CITY OF ALBUQUERQUE

December 8, 2016

**Re: AAA Roofing Storage space
2509 Comanche RD NE
Traffic Circulation Layout
Architect's Stamp 11-09-16 (G16-D004)**

SITE PLAN / TRAFFIC CIRCULATION LAYOUT

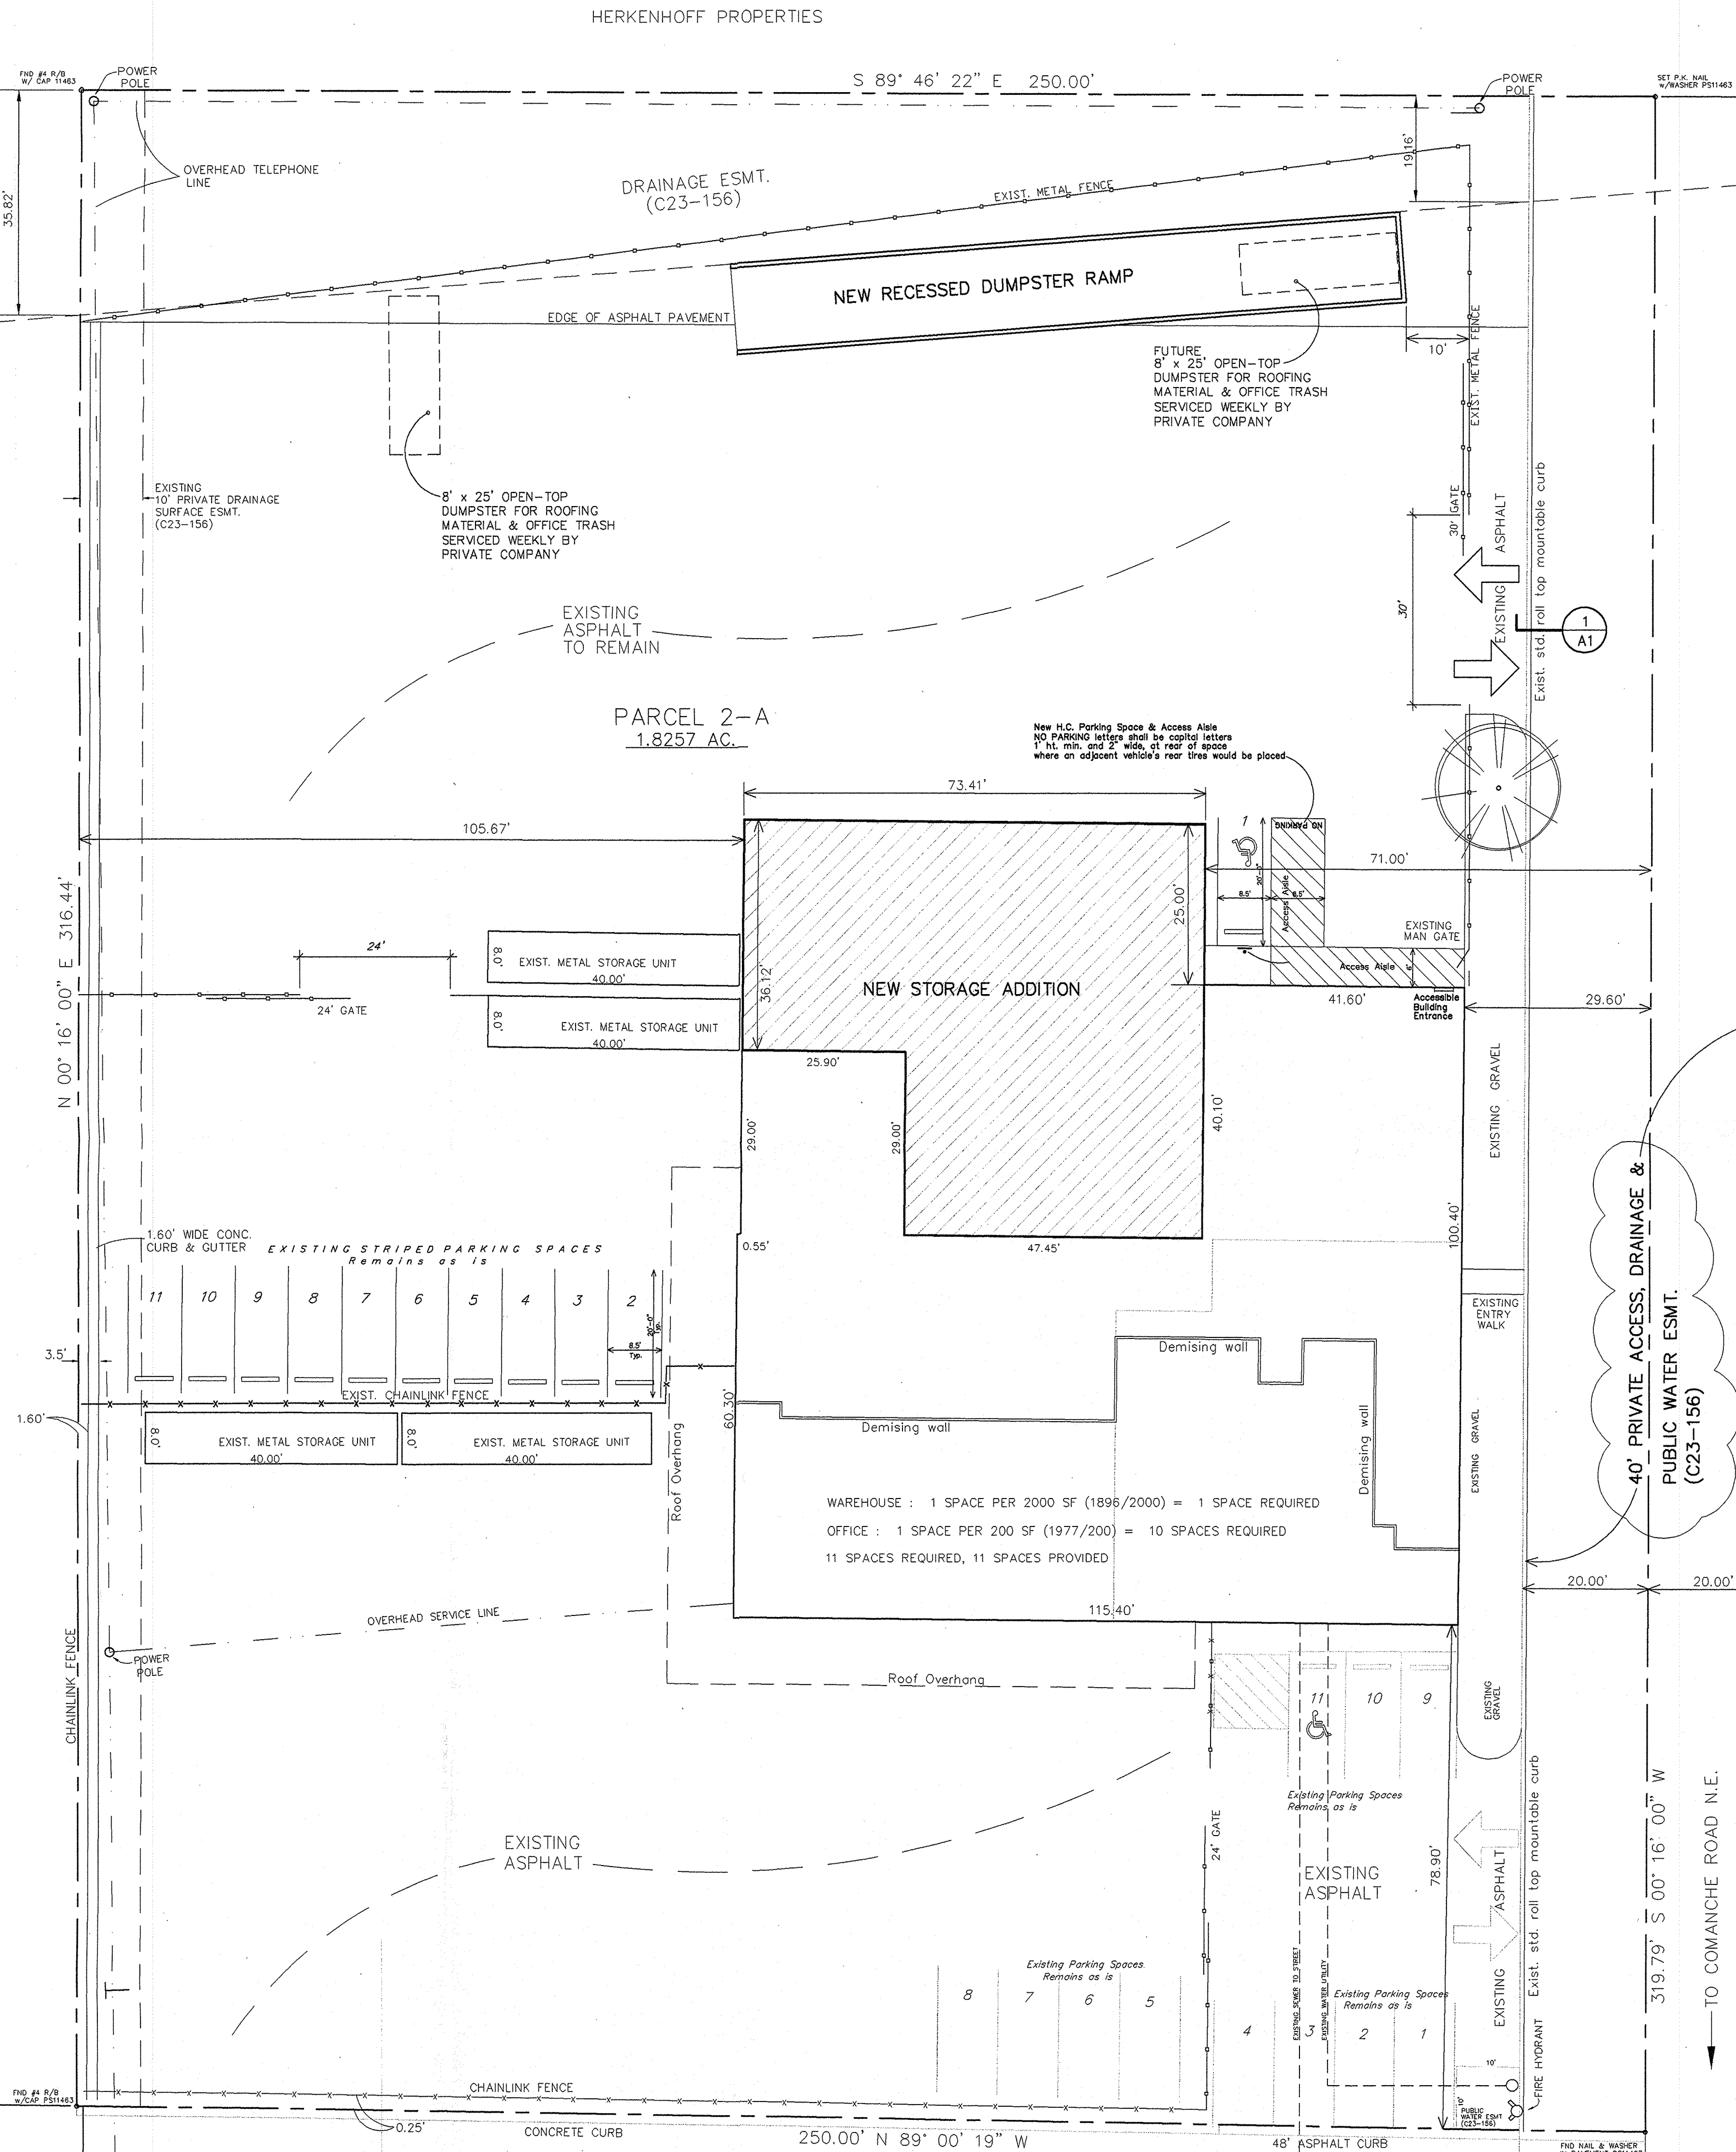
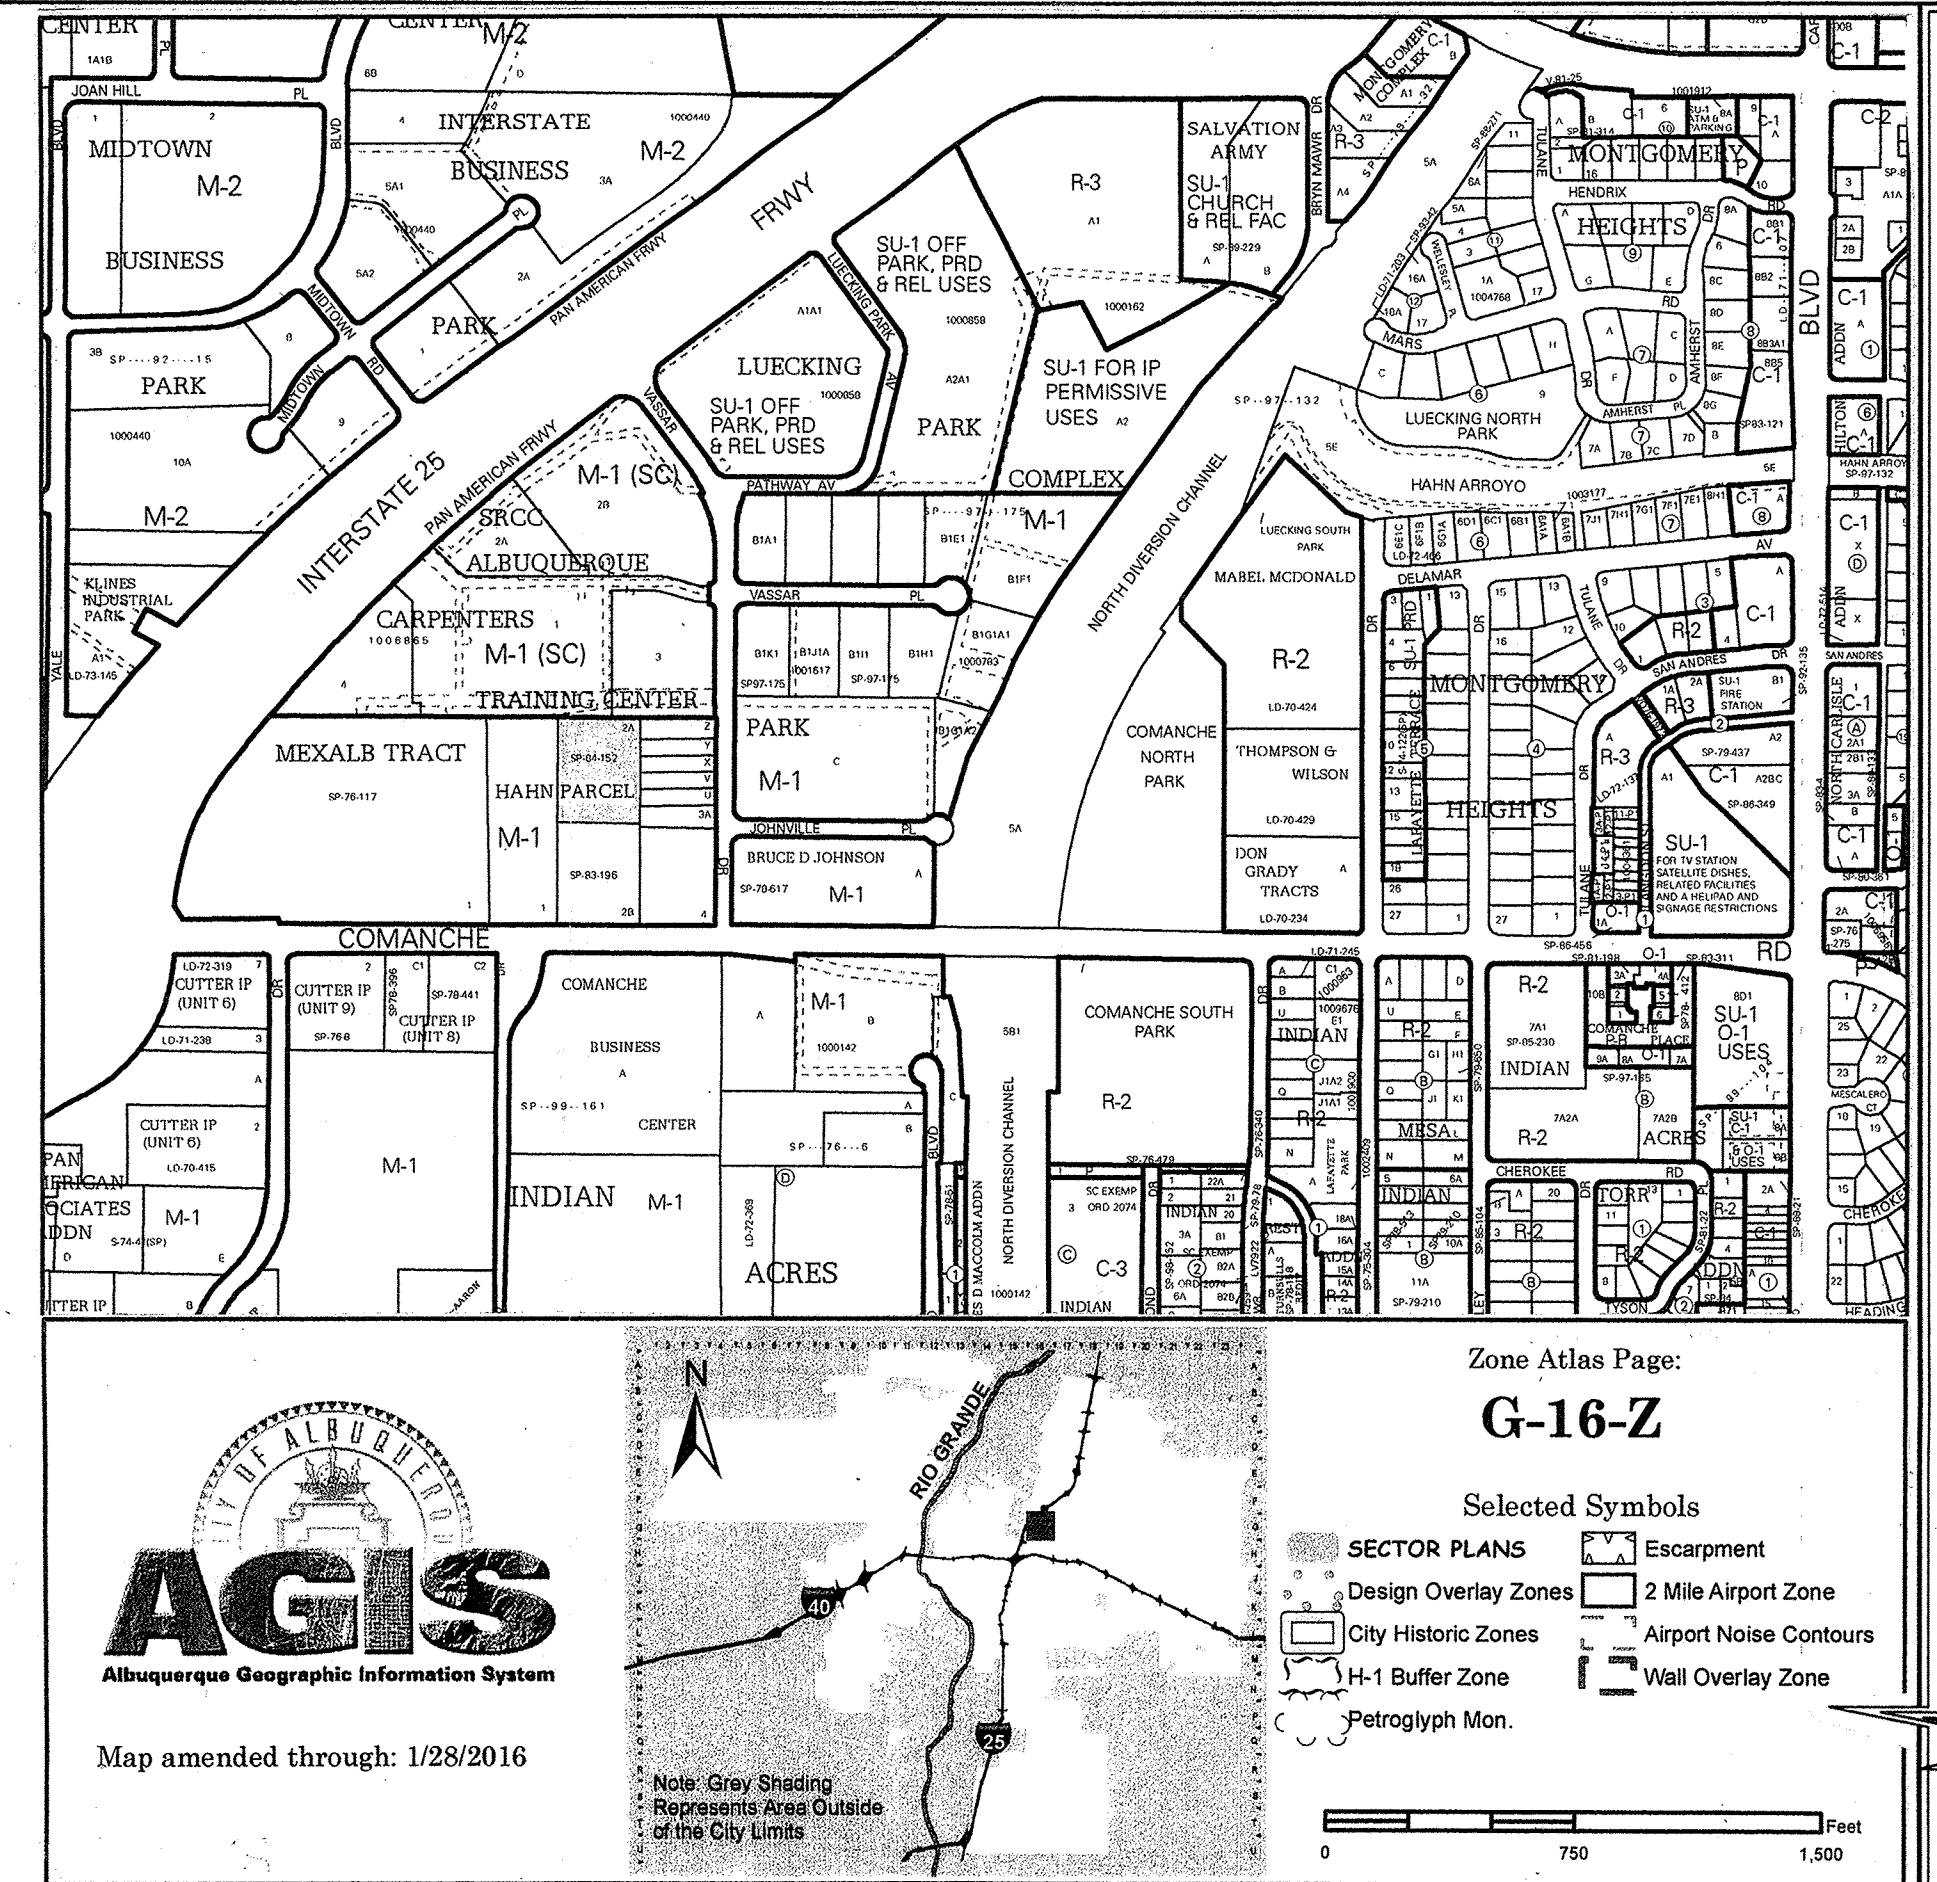
1. Please identify all accessible building entrances, drive entrance widths and anything that influences the parking and circulation on the site.
2. Please list the width and length for all existing and proposed parking spaces. Some dimensions are not shown. Indicate if existing parking will be restriped. Will the existing handicap parking remain? If so, it should be updated.

3. The ADA accessible parking sign must have the required language per 66-7-352.4C NMSA 1978 **"Violators Are Subject to a Fine and/or Towing."** Please call out detail and location of HC signs.

4. The ADA access aisles shall have the words **"NO PARKING"** in capital letters, each of which shall be at least one foot high and at least two inches wide, placed at the rear of the parking space so as to be close to where an adjacent vehicle's rear tire would be placed. (66-1-4.1.B NMSA 1978)

5. Per DPM, a 6 ft. wide ADA accessible pedestrian pathway is required from the HC parking stall access aisles to the building entrances. Please clearly show this pathway and provide details.
